12 November 2021

New Liverpool Primary School SSD – 10391

Response to Agency Submissions

**DRAWING**  
 LANDSCAPE PLAN

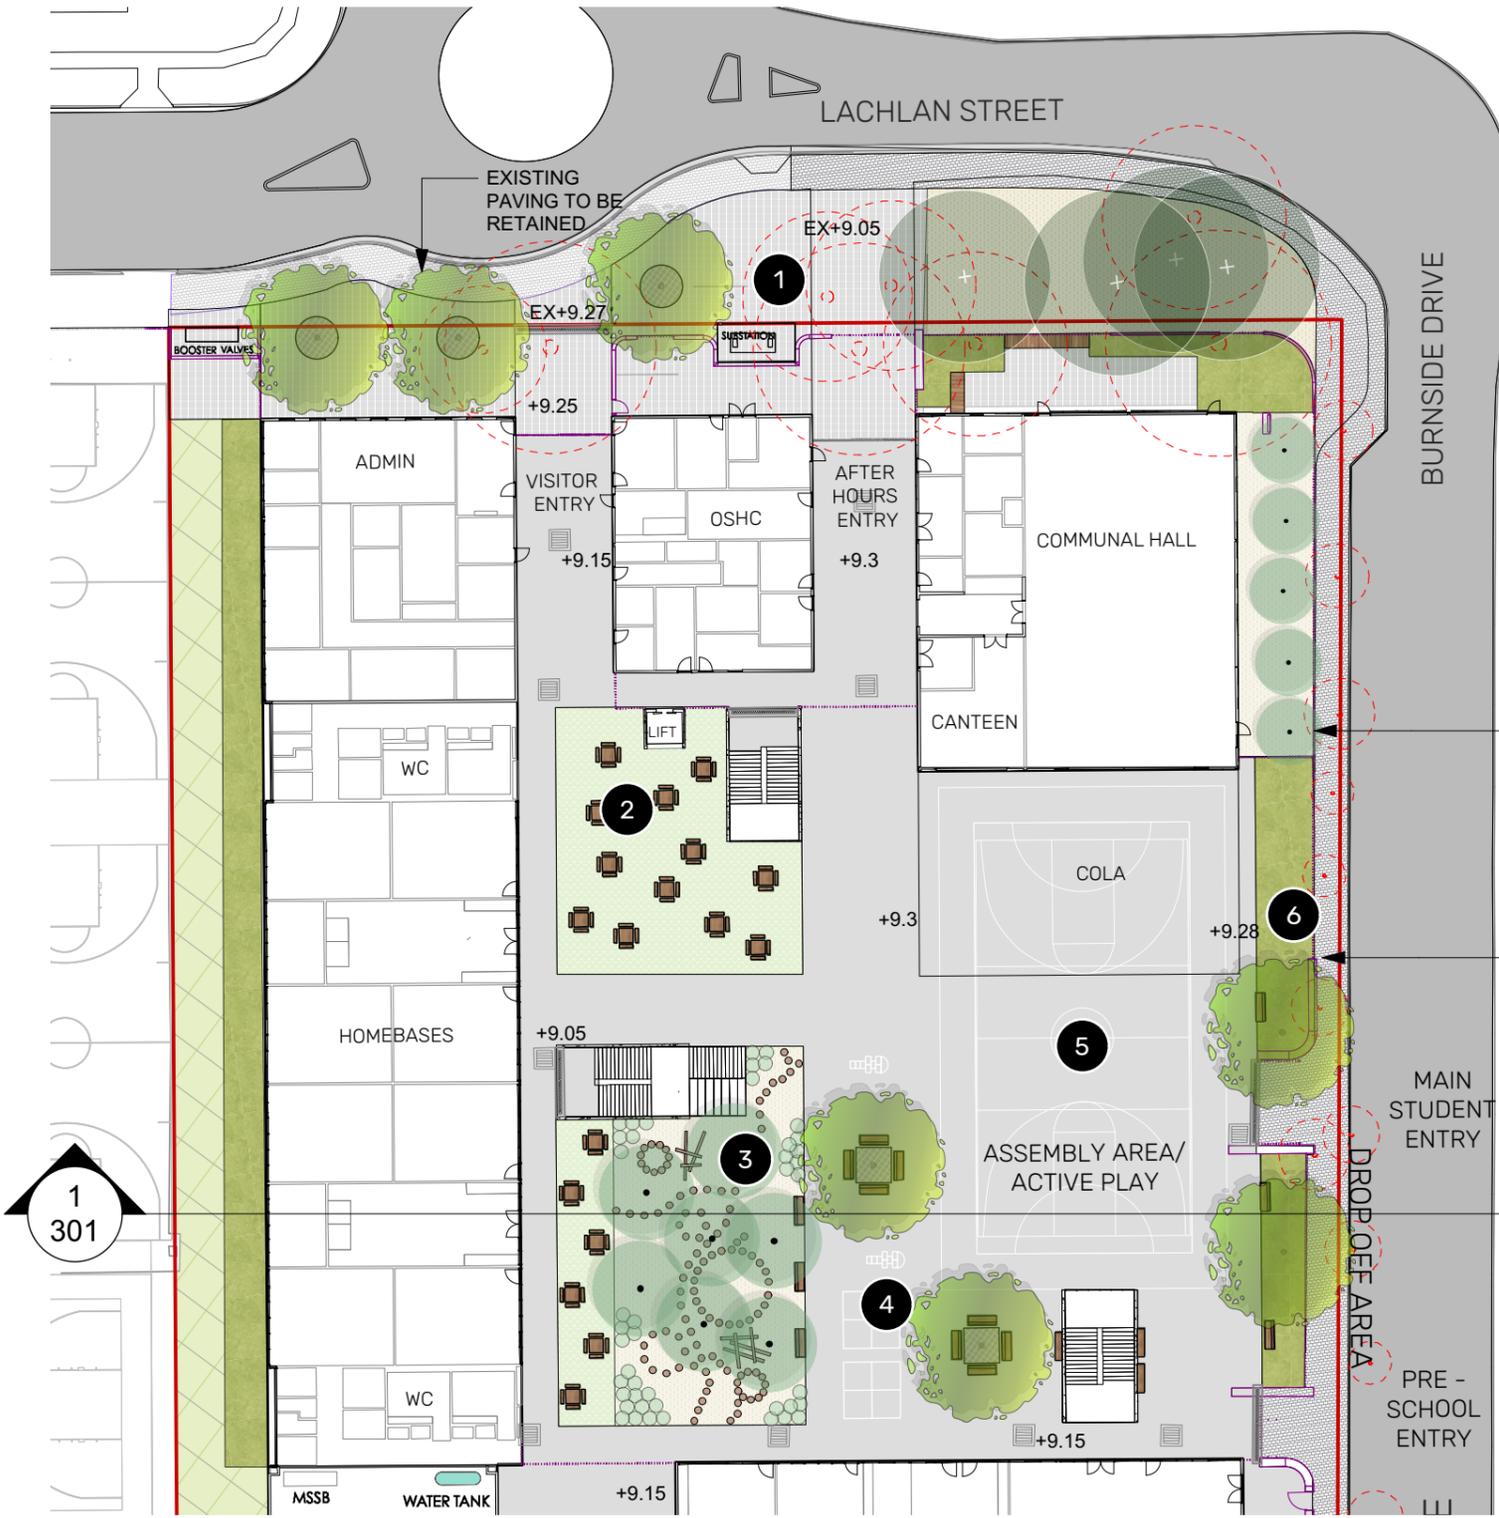
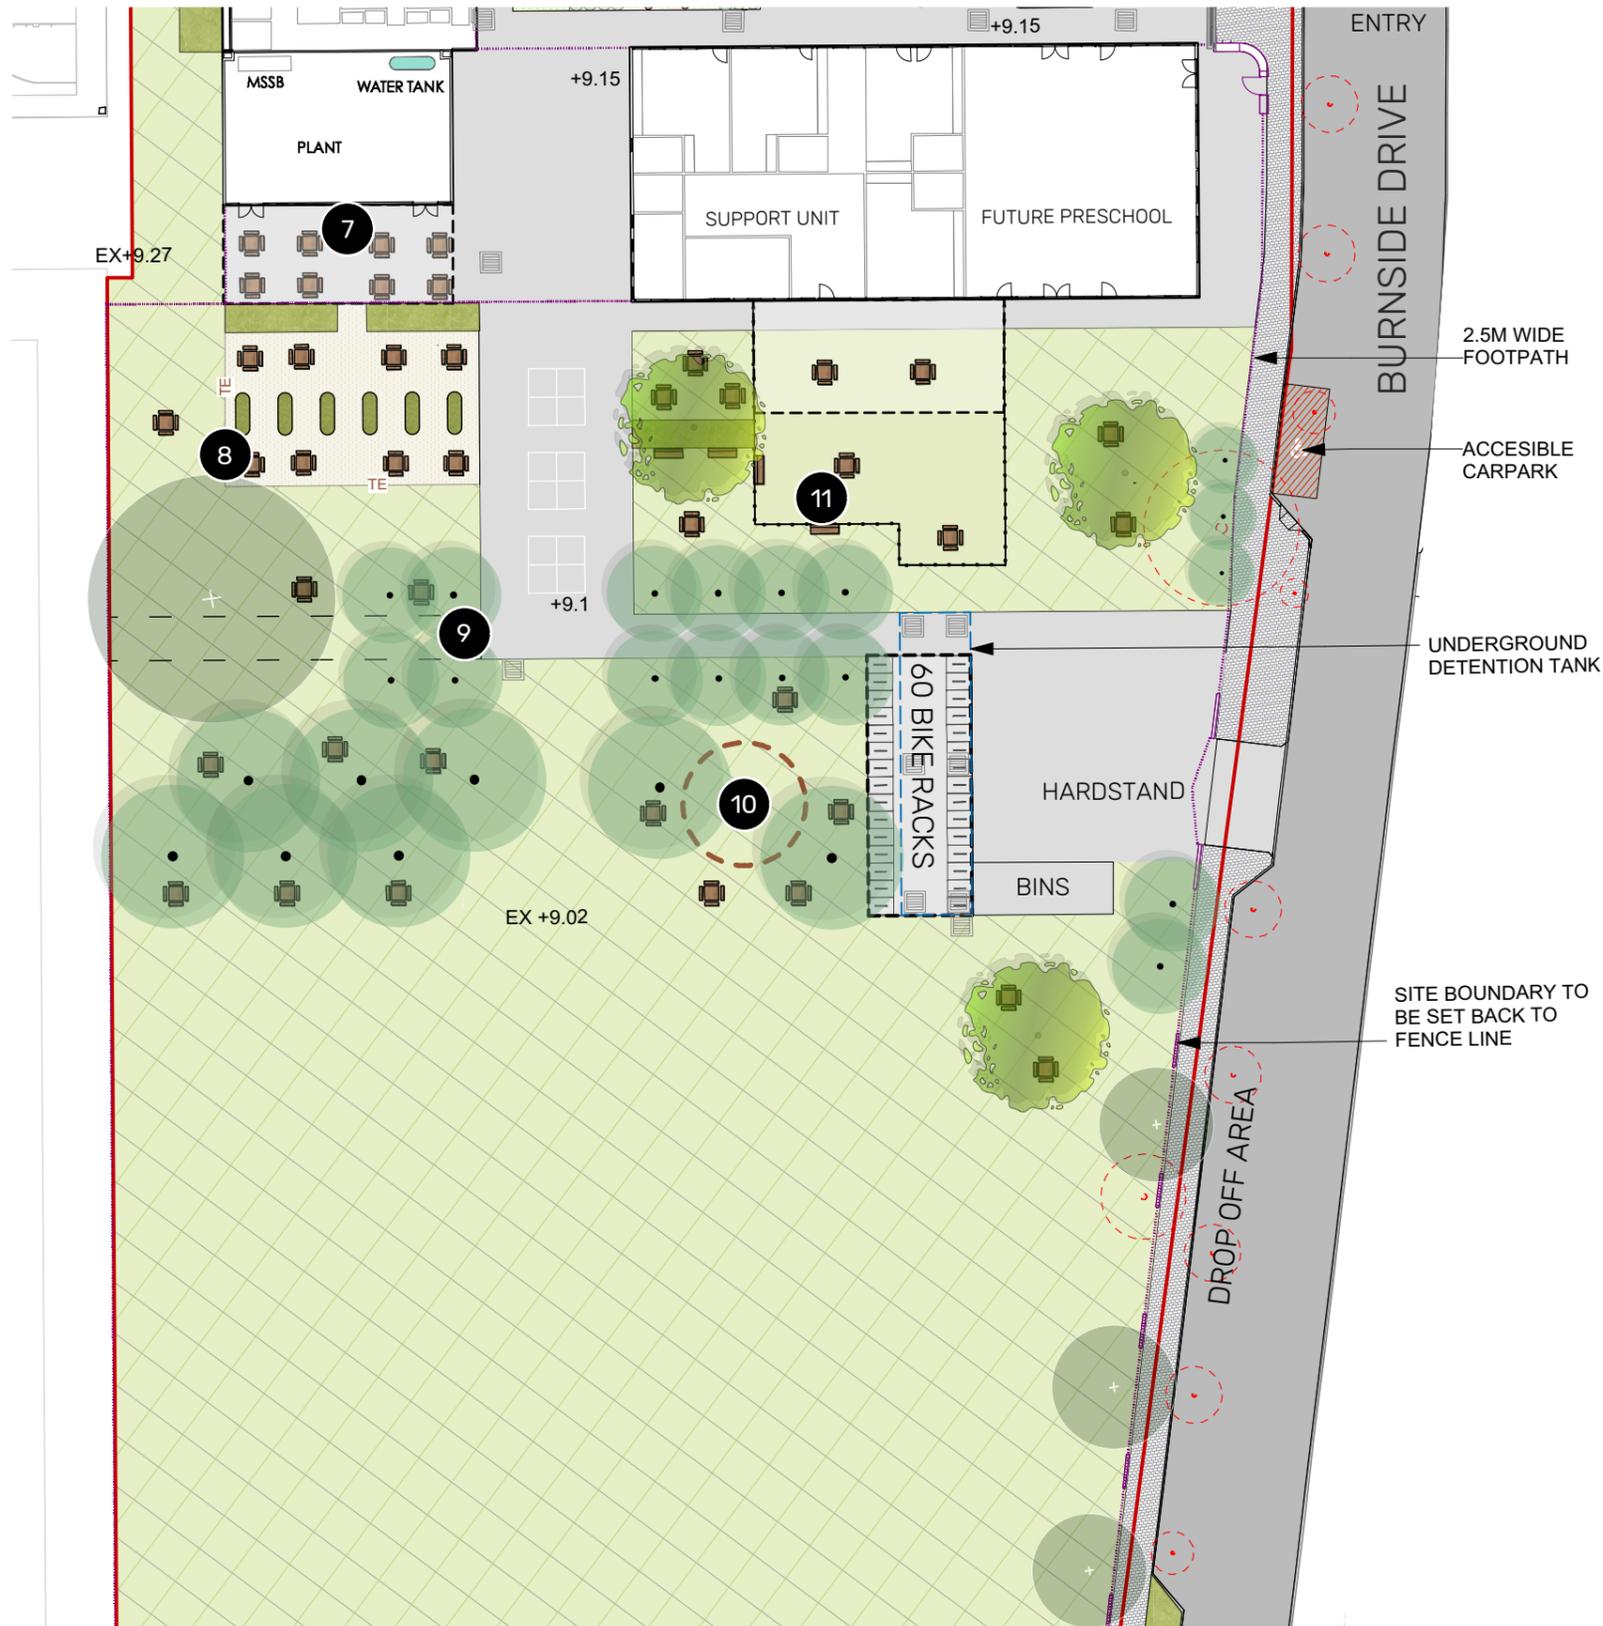
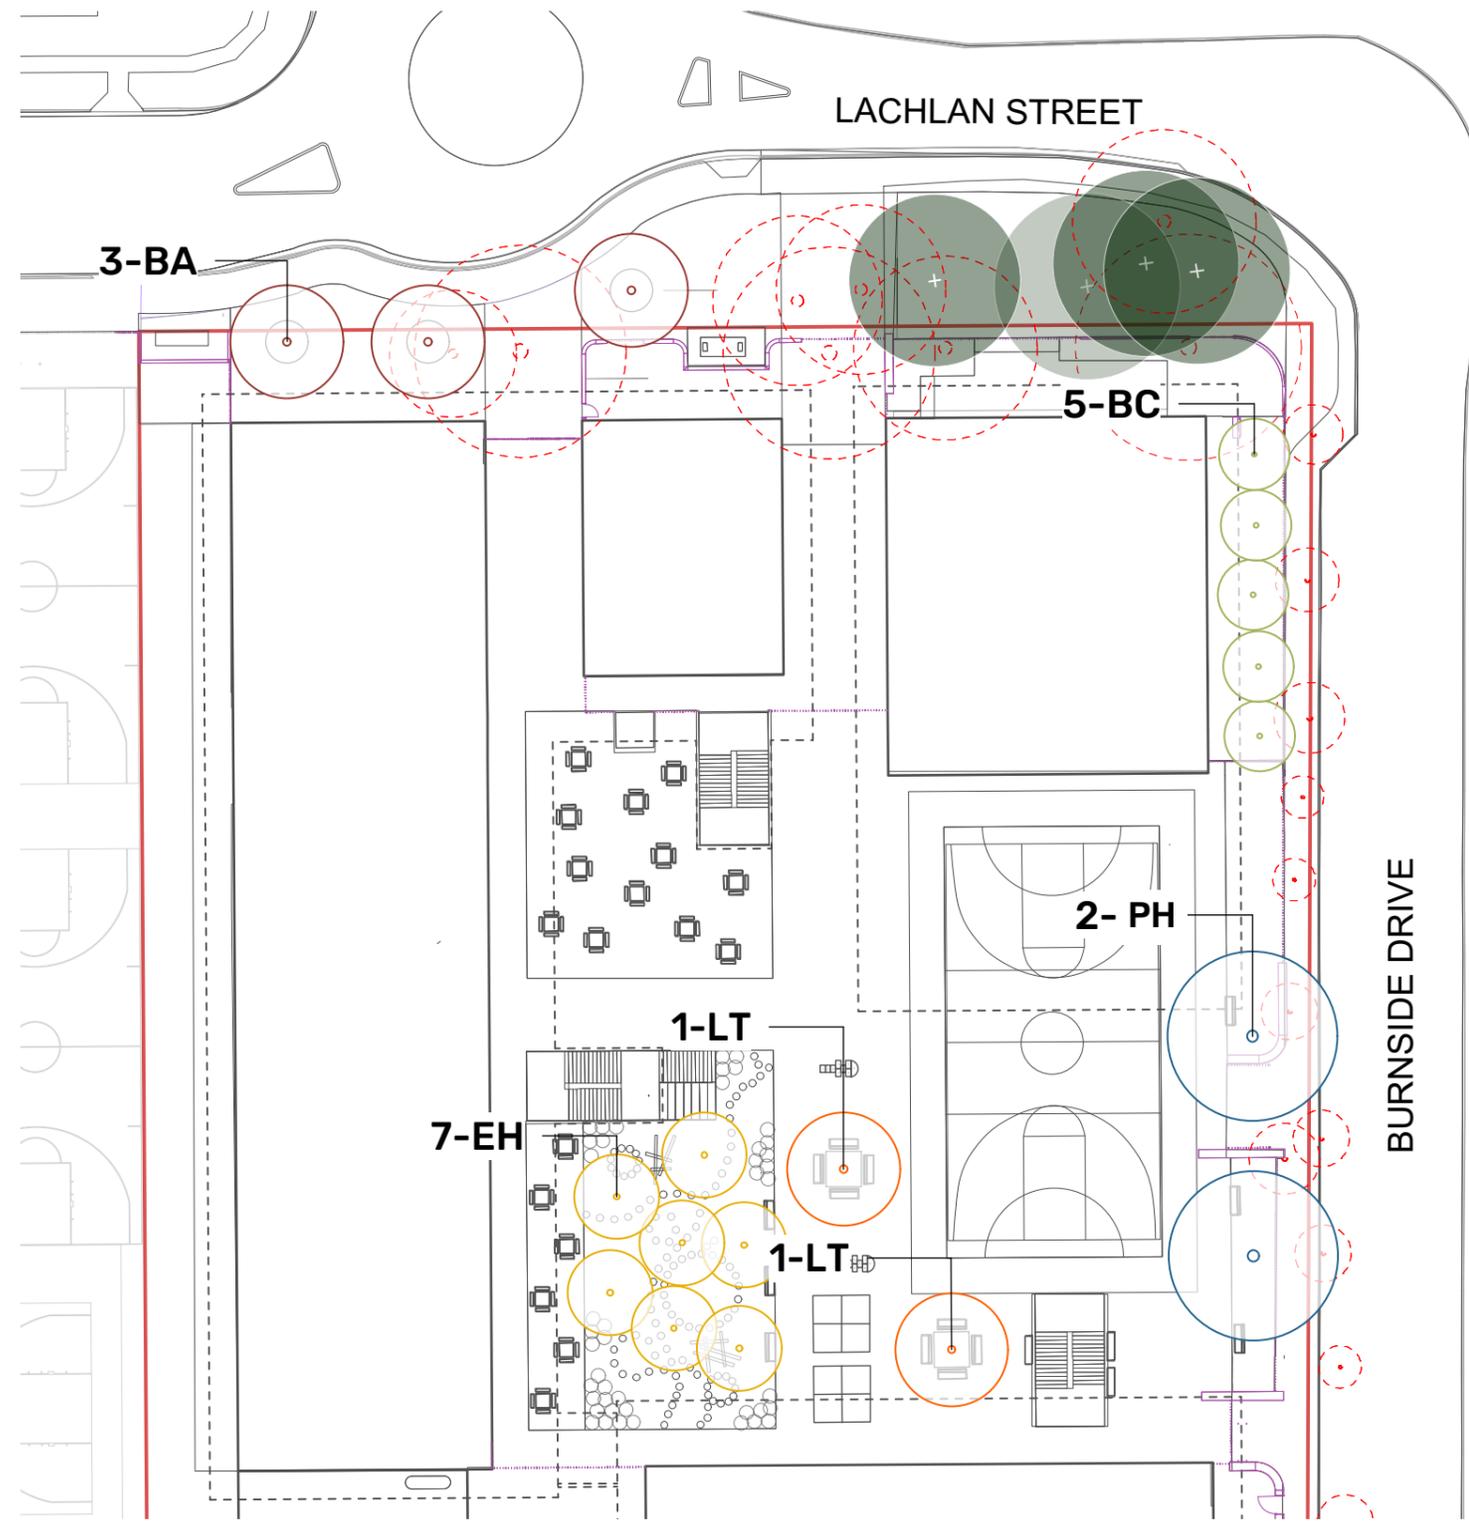
Comment	Response
<p>The submitted site plan, Ground Plain Plan and Ground Plan Drawings No NLPS-AR-DRG-SSDA-0005-7 are showing a landscaping strip along with the western boundary. However, the submitted Landscape plan does not show any trees being planted along with the western boundary. Please amend the landscape drawing to eliminate the discrepancy. Also, please note that the Department recommends that trees be planted along the western boundary to act as a sub shade for the building in the future."</p>	<p>Noted. The error is acknowledged. Please refer to the coordinated proposed site plan at Appendix B of the RTS. SINSW advise that there are no trees proposed on the western boundary due to the potential security and safety risks.</p> <p>Please refer to the Landscape Drawings at Appendix C of the RTS for detailed tree schedule, including pot sizes.</p>
<p>The proposed development does not include details of disabled parking spaces. In this regard, the Department concurs with SDRP that the school is proposed to cater for special needs students and would therefore require access to disabled parking spaces and/or dedicated drop-off/pick-up spaces for these students in a convenient location. You are requested to provide additional information to demonstrate that these facilities are provided as part of the proposal.</p>	<p>Please refer to the additional drawing of the accessible parking Appendix F of the RTS, which indicates the carpark has two accessible car parking spaces.</p> <p>The drop off and pick-up spaces will be managed by the school. There is a SSU dedicated pick up/ drop off spots which are designed to accommodate disabled persons. Please note it is common practice for the staff to meet the SSU students at the dedicated drop off/ pick up areas and escort them to classrooms. Refer to plan at Appendix F for location of the dedicated SSU spot.</p> <p>The accessible space in the Kiss and Drop will be timed as 15min P as a Mobility Parking Scheme (MPS) space. The accessible space in the staff parking bay complies with BCA.</p>

<p>Following the consistency review of the Response to Submissions Documentation, DPIE noted the following as per the Environment, Energy and Science Group's submission:</p> <p><i>There are two Sapium sebiferum trees which have been proposed are classified as weeds.</i></p>	<p>The species will be swapped from the Sapium sabiferum to a Platanus x hybrida on the Landscape Architect's recommendation. The landscape plans have been amended to reflect the revised species, see Appendix C.</p>
